Date: June 3, 2022

FROM: Margaret Haynes, NMDOT Assistant District 3 Traffic Engineer

SUBJECT: Upper Petroglyph Phases (1-7) Traffic Impact Study  
North of I-40, West of Atrisco Vista Blvd.  
Albuquerque, Bernalillo County, New Mexico

The NMDOT received the DRAFT TIS dated March 1, 2022. District Three's comments are below.

PEAK HOUR VOLUME SIGNAL WARRANT ANALYSIS

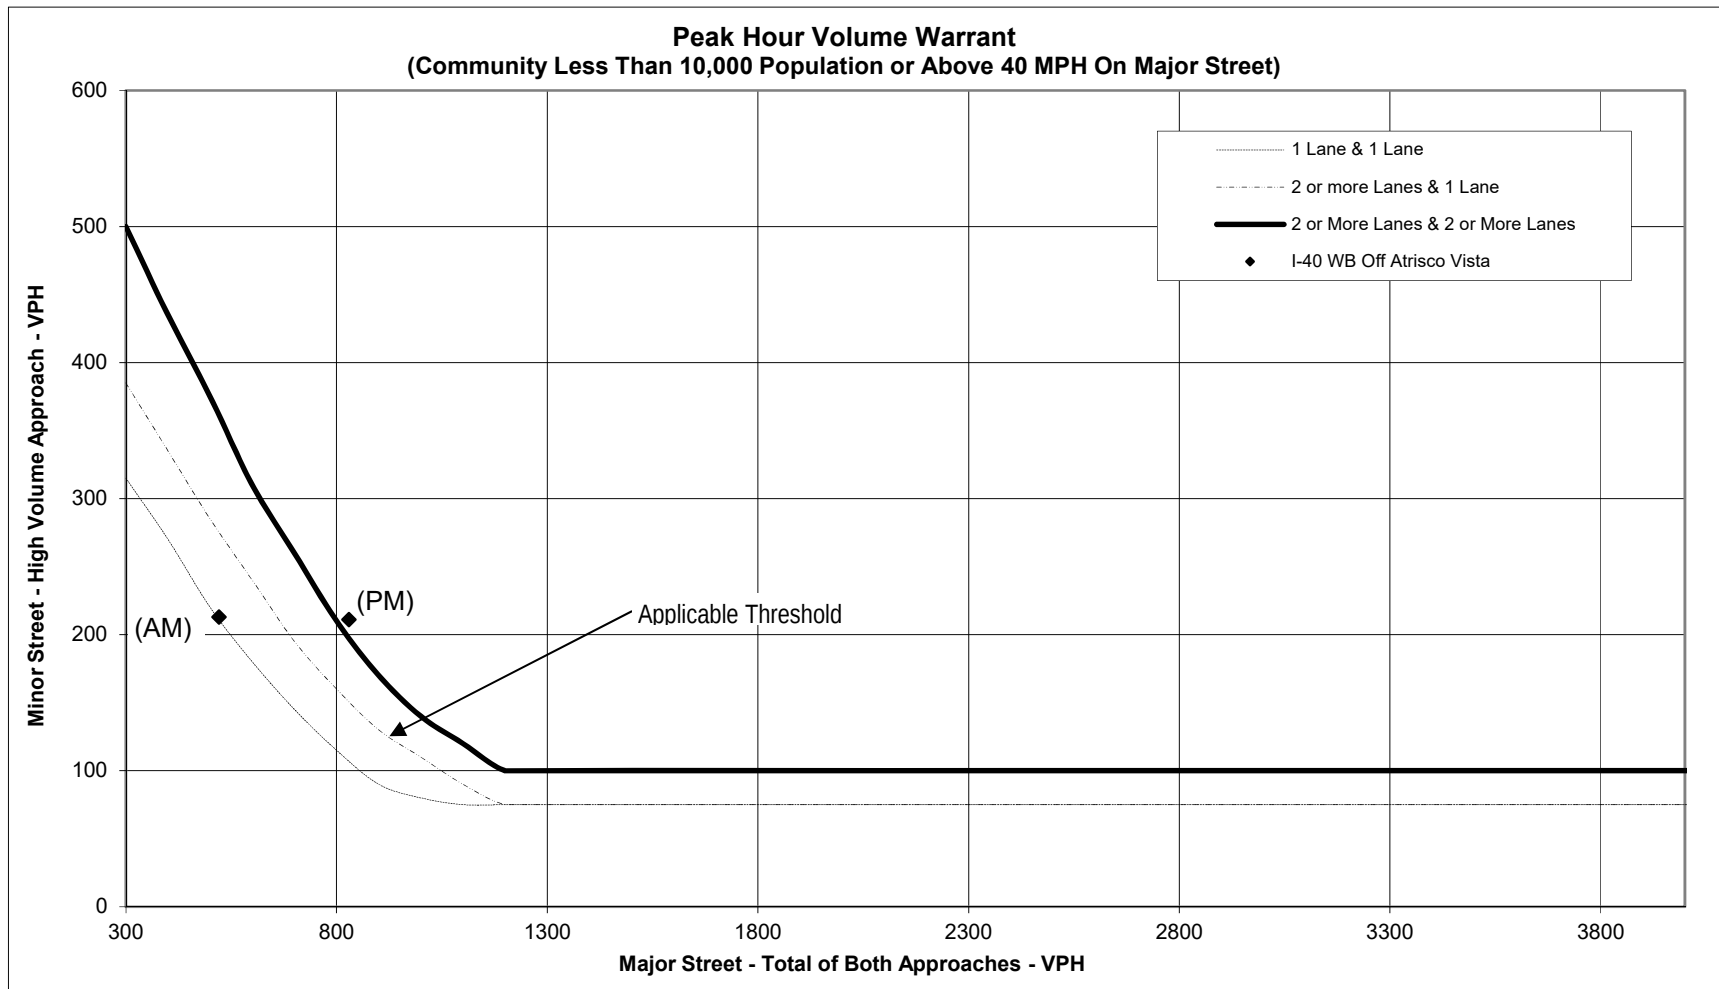
Page 60 – At I-40 EB off ramp and NM 500, was a signal warrant analysis checked in the 2027 build analysis year?

Page 141 – At Atrisco Vista and I-40 westbound off-ramp what are the recommended striping changes. Please include here.

FIGURE 3
PHASE I

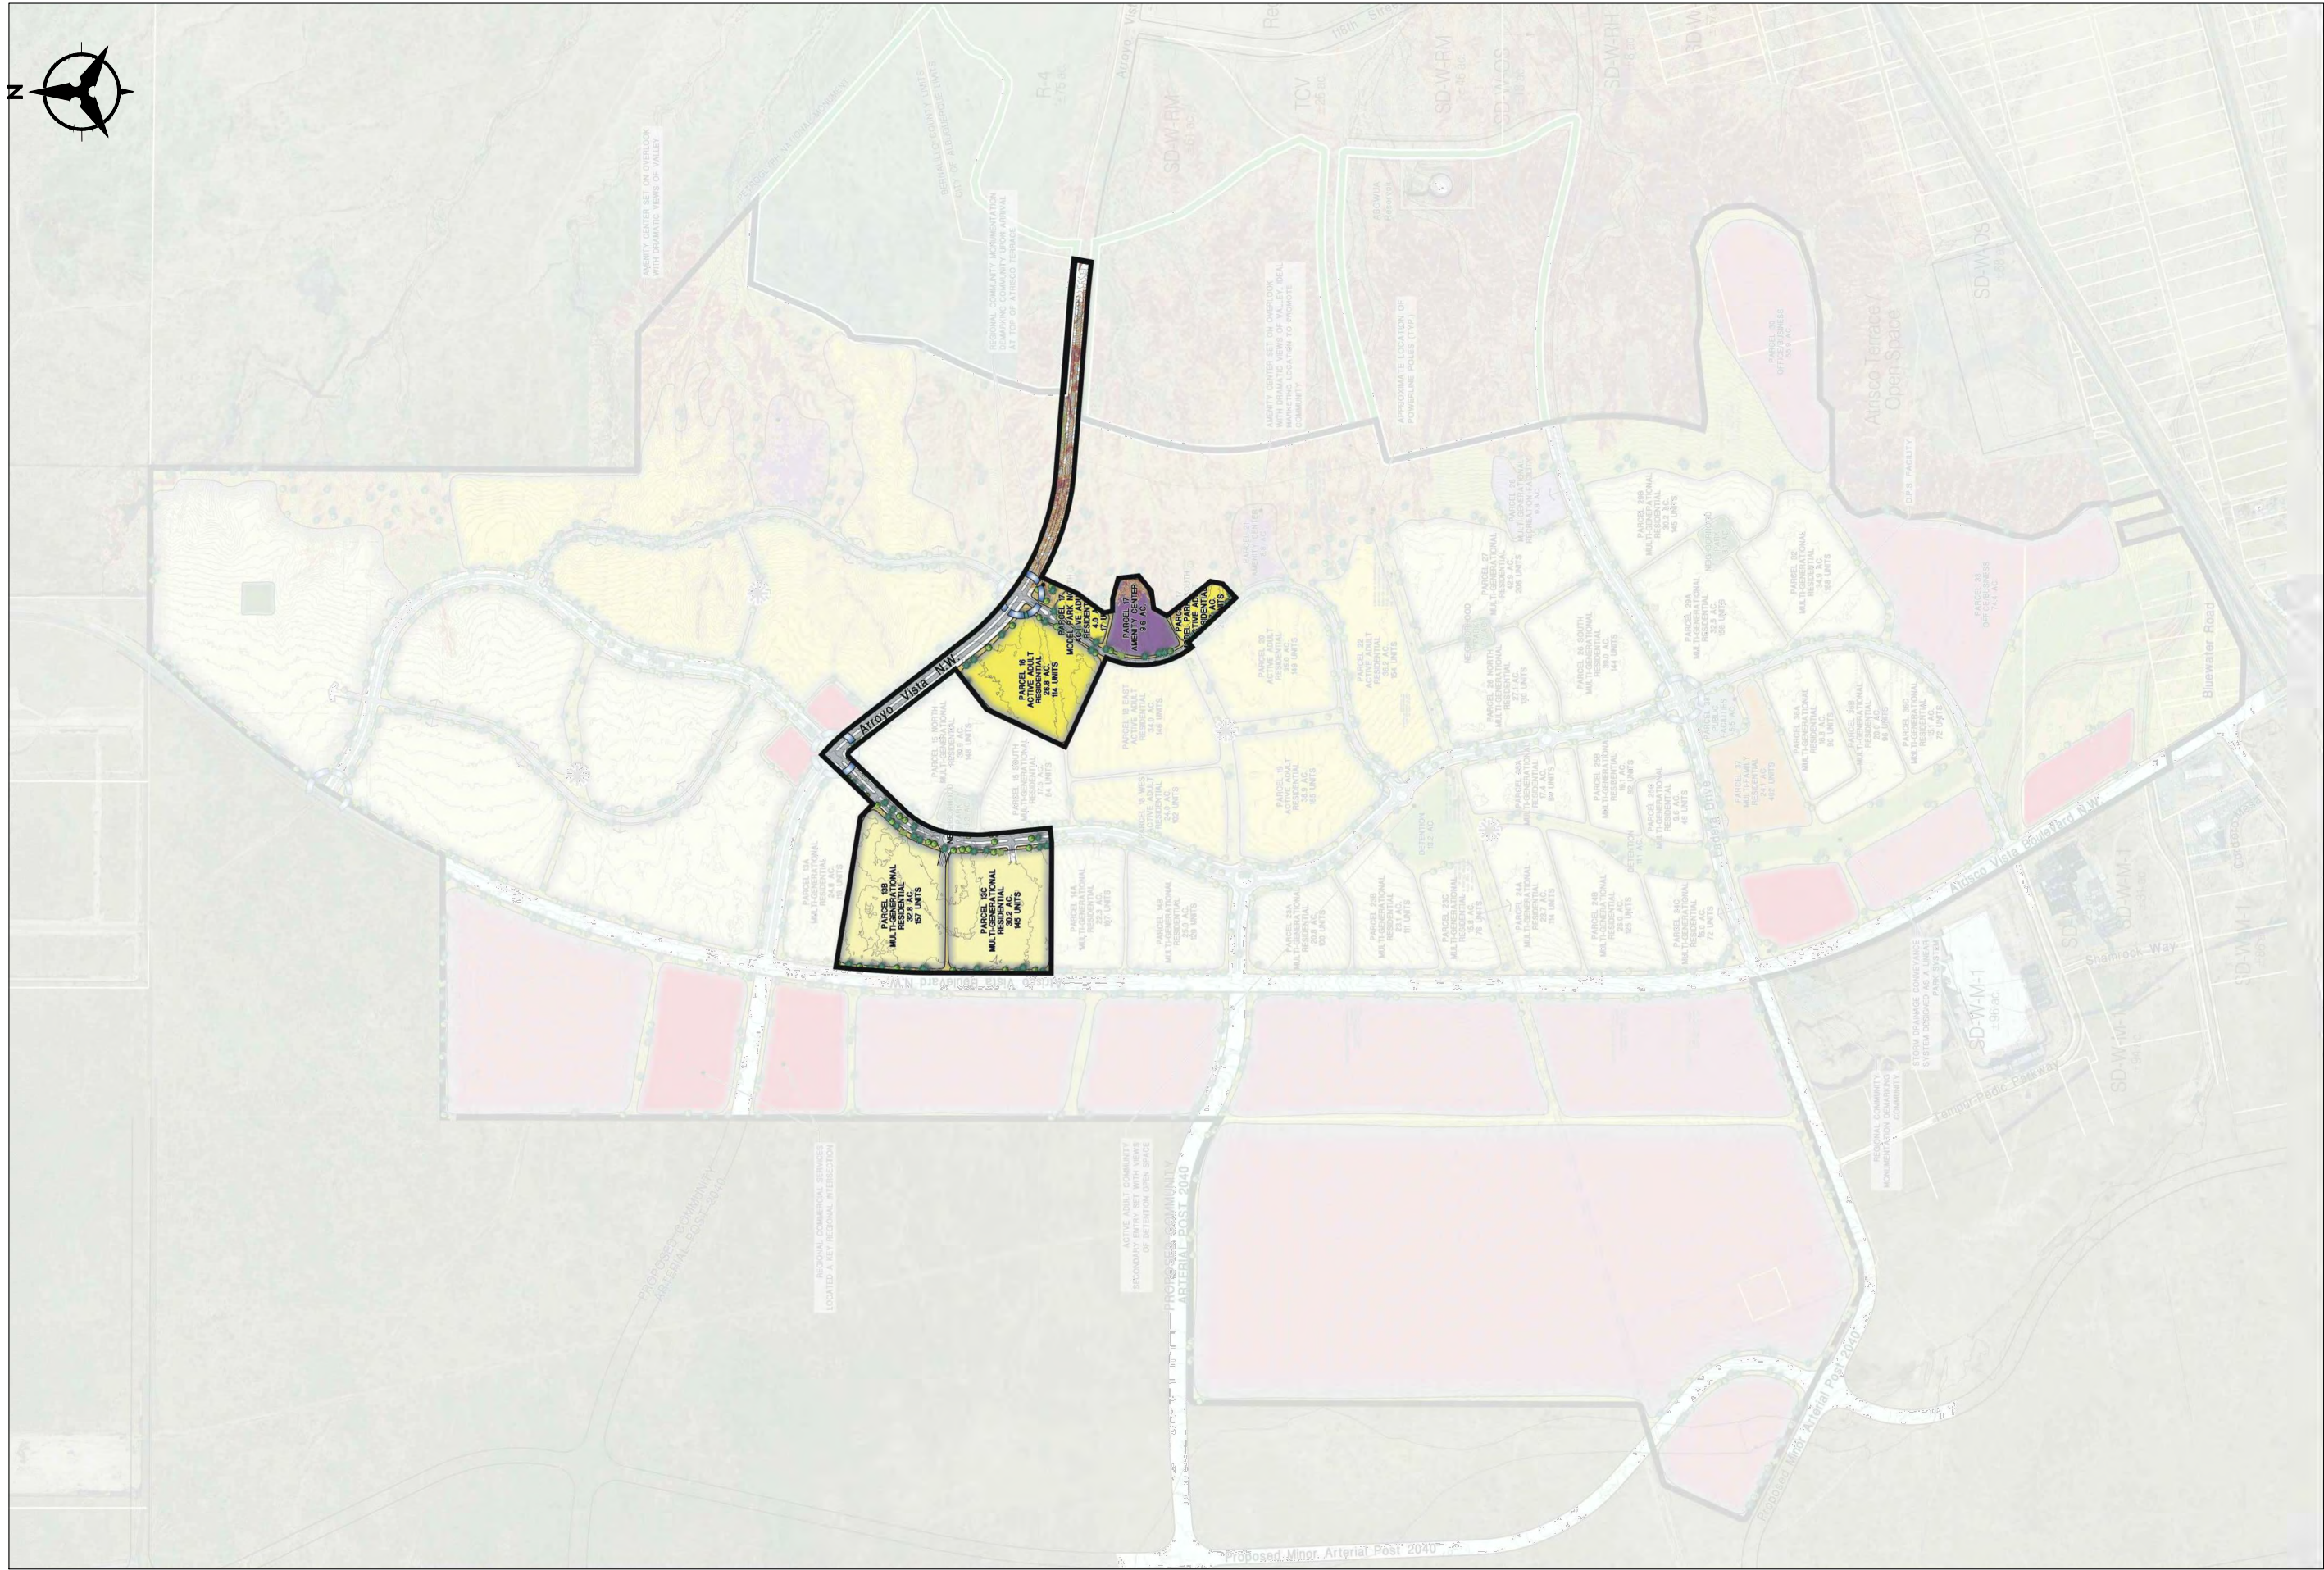
Page 26 – In Figure 4 it's hard to tell what is included in the phases. There is type, there is handwriting, and other black outlined areas. What is included? Can you add a key?

FIGURE 6
INTERSECTIONS
TO BE STUDIED

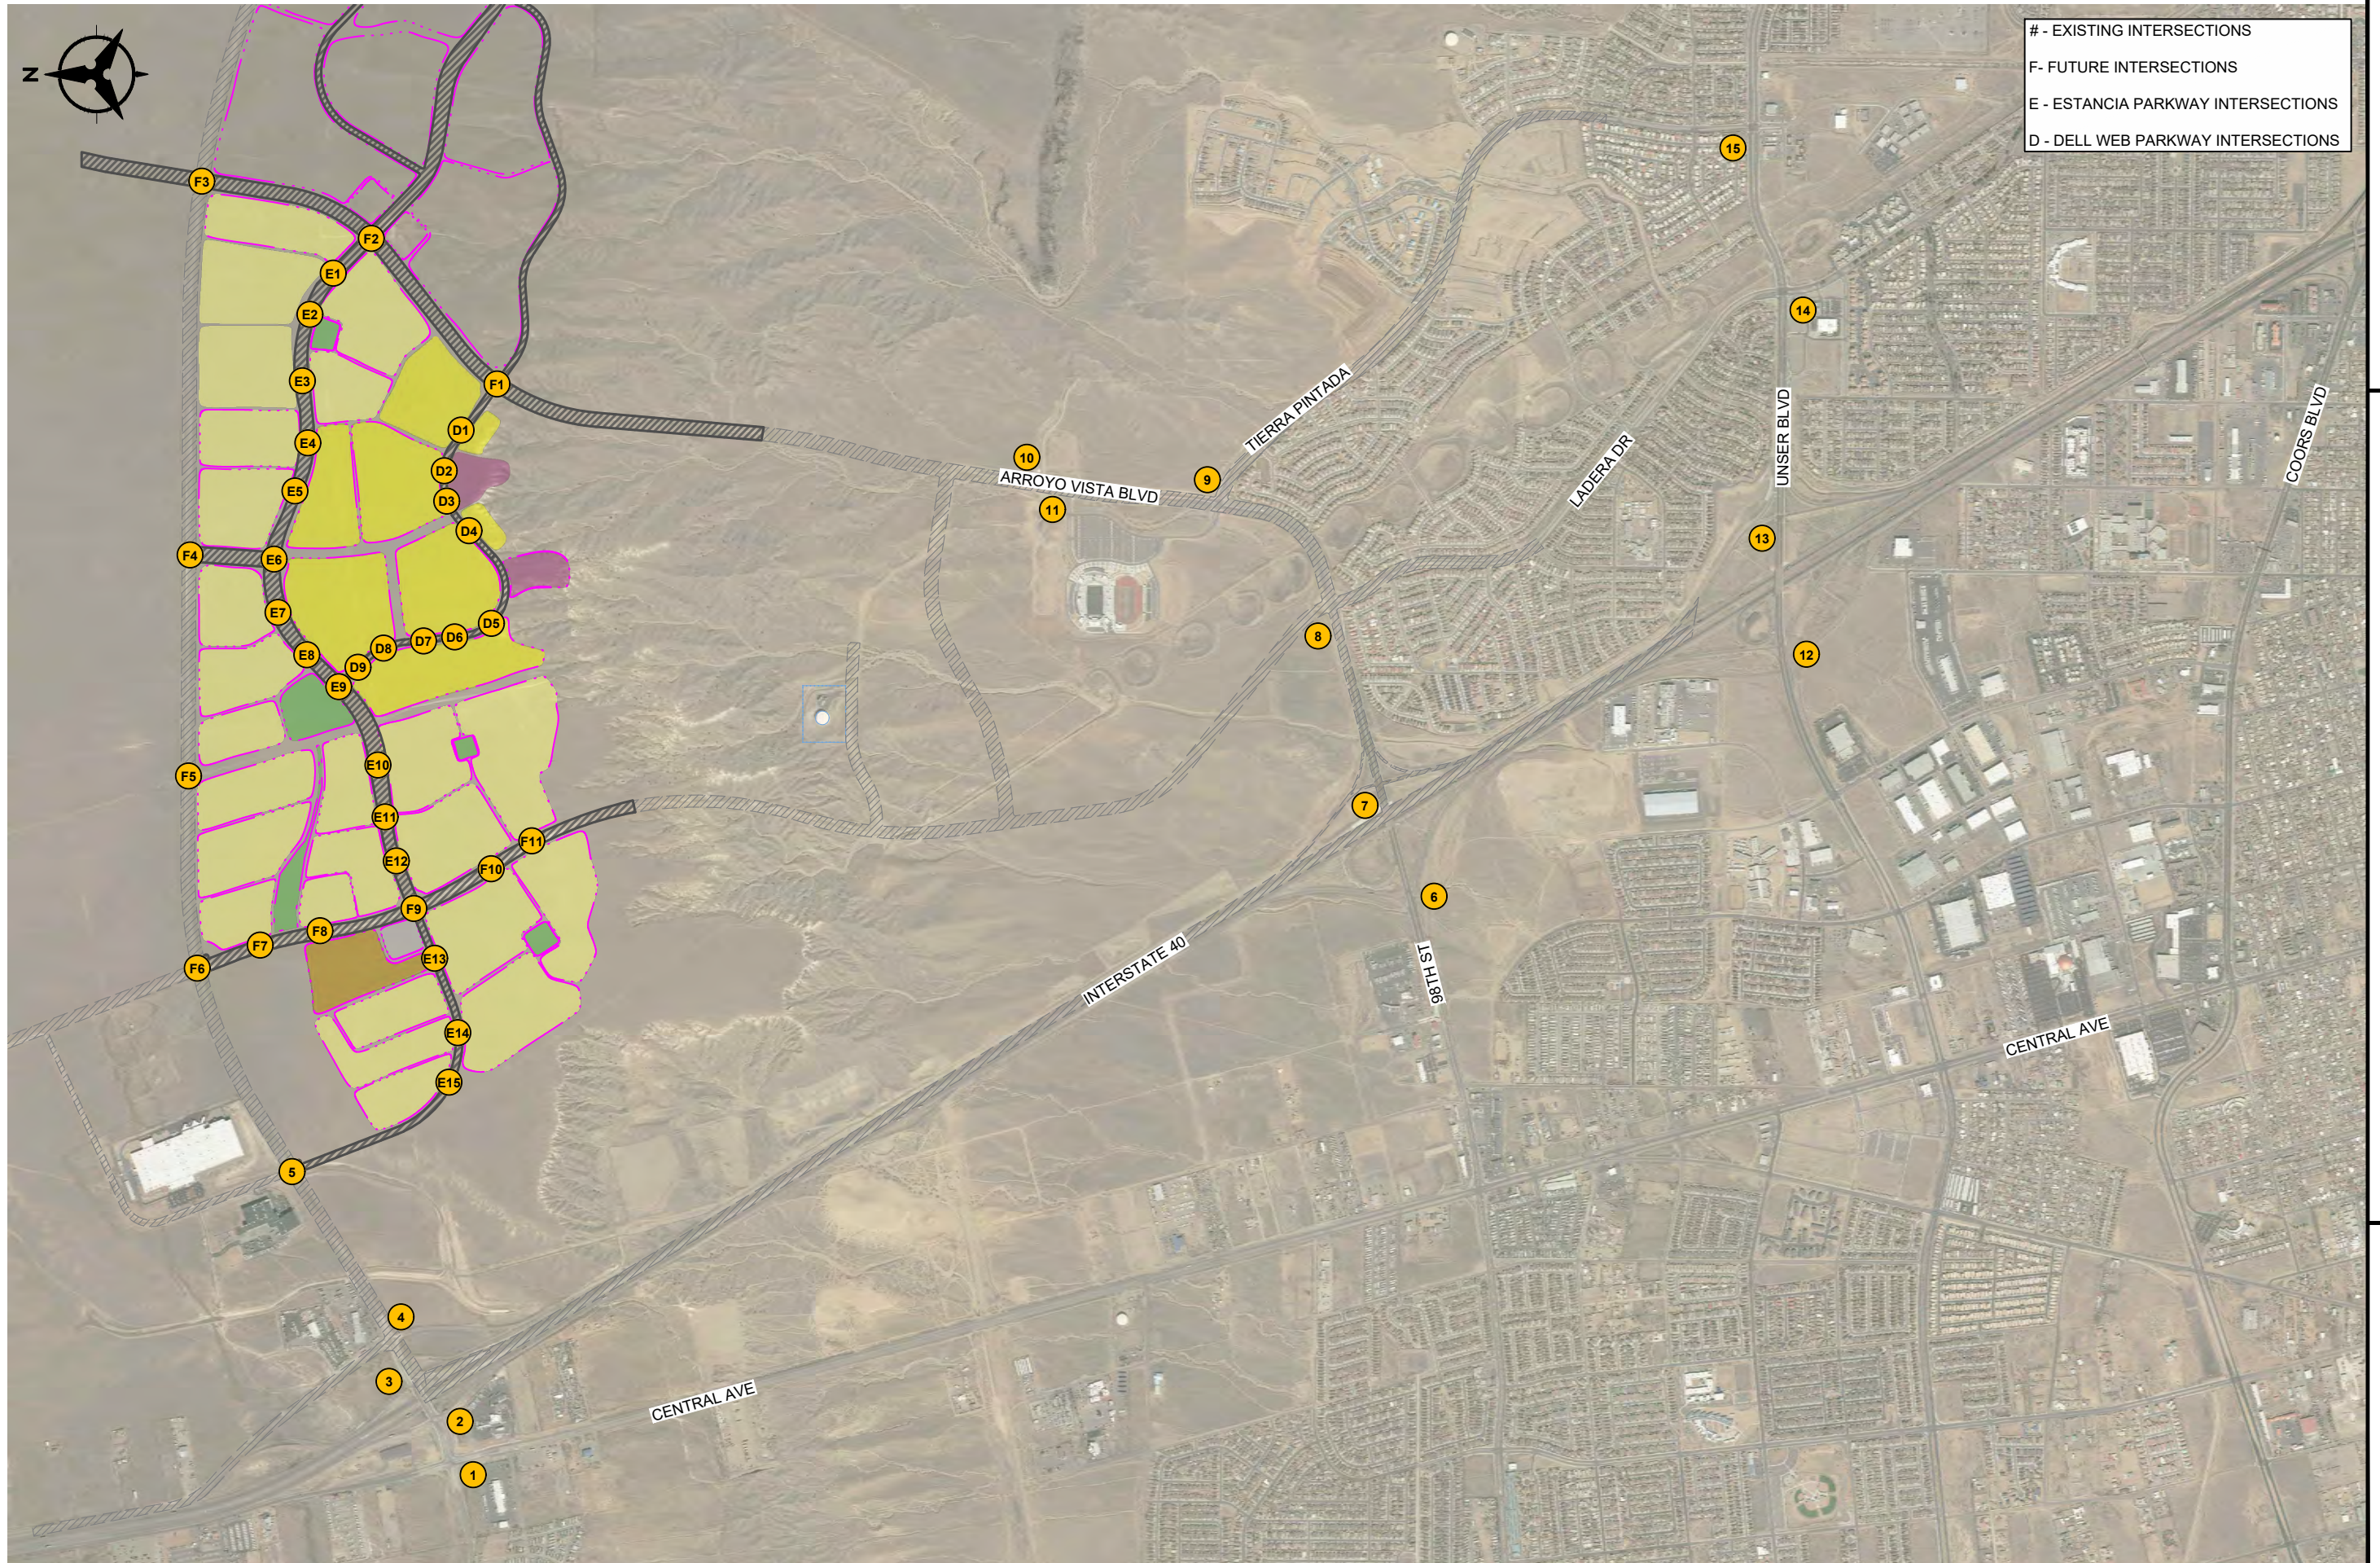
Page 2 – It would be helpful to have a map that identifies the existing and future intersections.
